Subject: FW: AB/39/21/DOC - 19 Maltravers Street, Arundel

I am e-mailing you in respect of the above approval of details reserved by condition imposed under ref AB/125/20/L relating to Condition Nos 3 - details of junction between elevation of extension & flat roof including materials, 4 - materials & finishes for brick & brick bond, 5 - details of new external door including materials, finish & method of glazing, 6 - materials & finishes for rooflight and 7 - details of internal window including proposed glazing

Section A-A

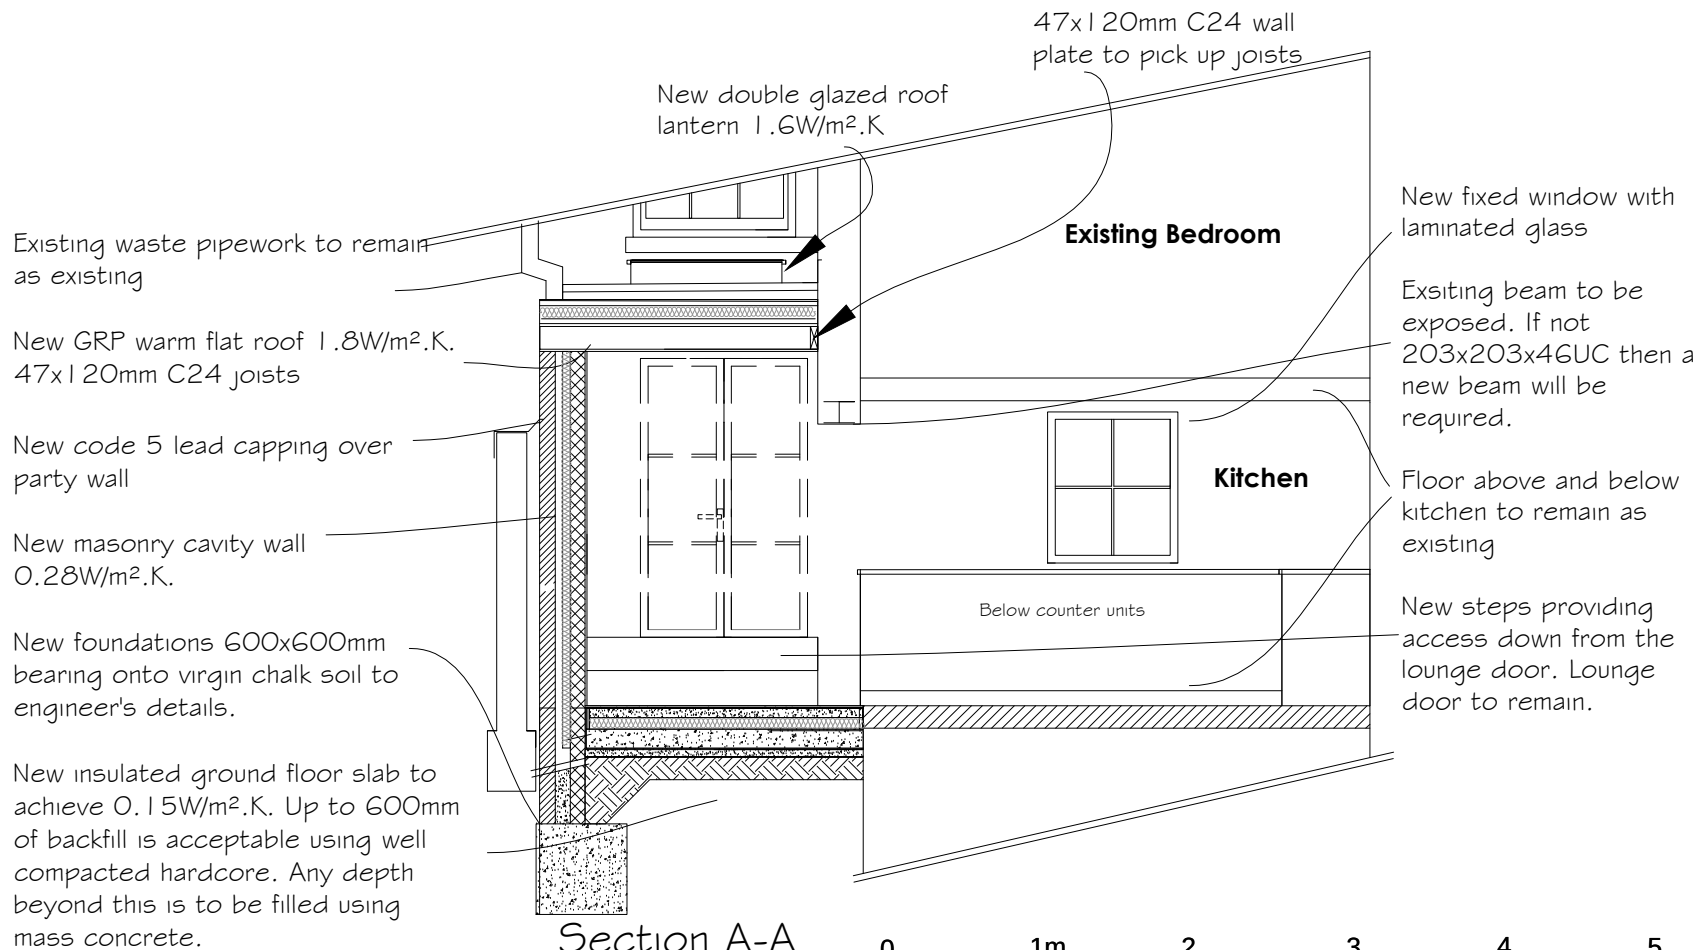
I also note that the intention is to revise the treatment of the small areas either side of the rear elevation door from brick to render and use the same paint colour as already present on the listed building. Whilst this approach is likely to be acceptable, it can't be submitted as discharge of condition application since the treatment of the wall was detailed on the approved plans and there are no conditions relating to submission of render for approval. In order to make this change a new application for Listed Building Consent will need to be submitted for consideration.
